East Anglia THREE
Offshore Windfarm

Revised Design and Access Statement (Schedule of Changes)

Document Reference – Deadline 5/ Second
Written Questions/ DAS (Schedule of Changes)/
LH16

Schedule of changes to the Design and Access Statement (as at October 2016)

Figure 2 Grid Transmission Procurement – Indicative Timing

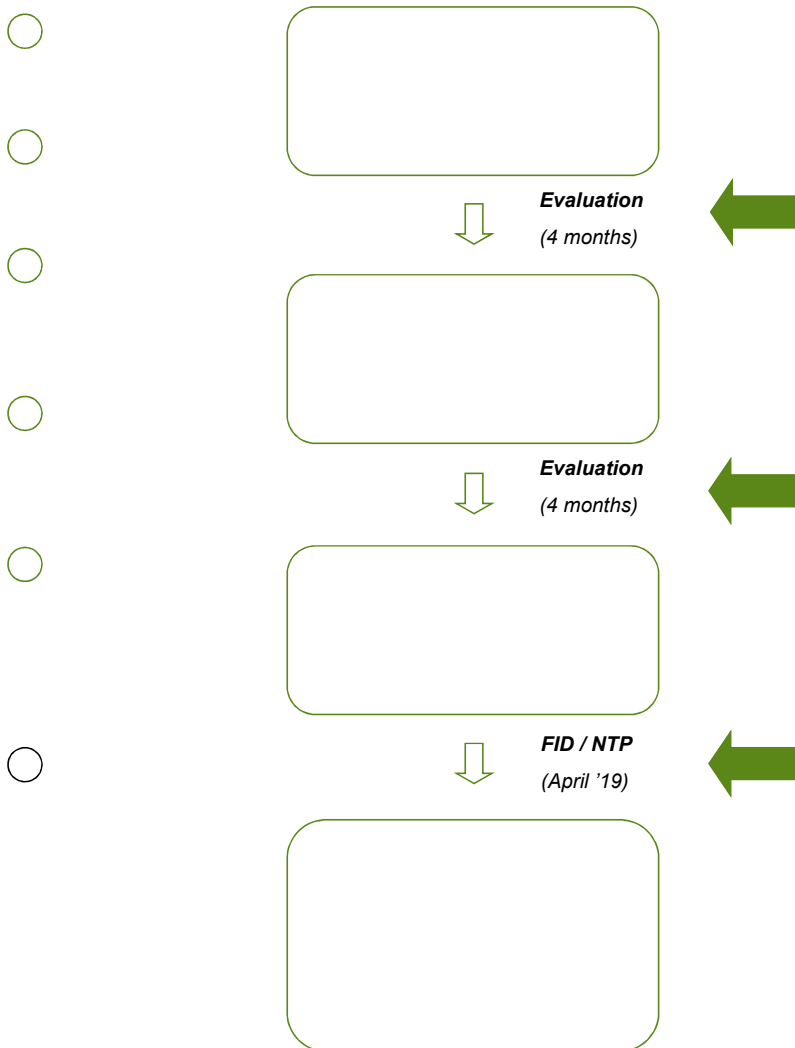
Figure 2	N/A	N/A	N/A	<u>Note that this is indicative and that the diagram does not consider award of Contracts for Difference.</u>
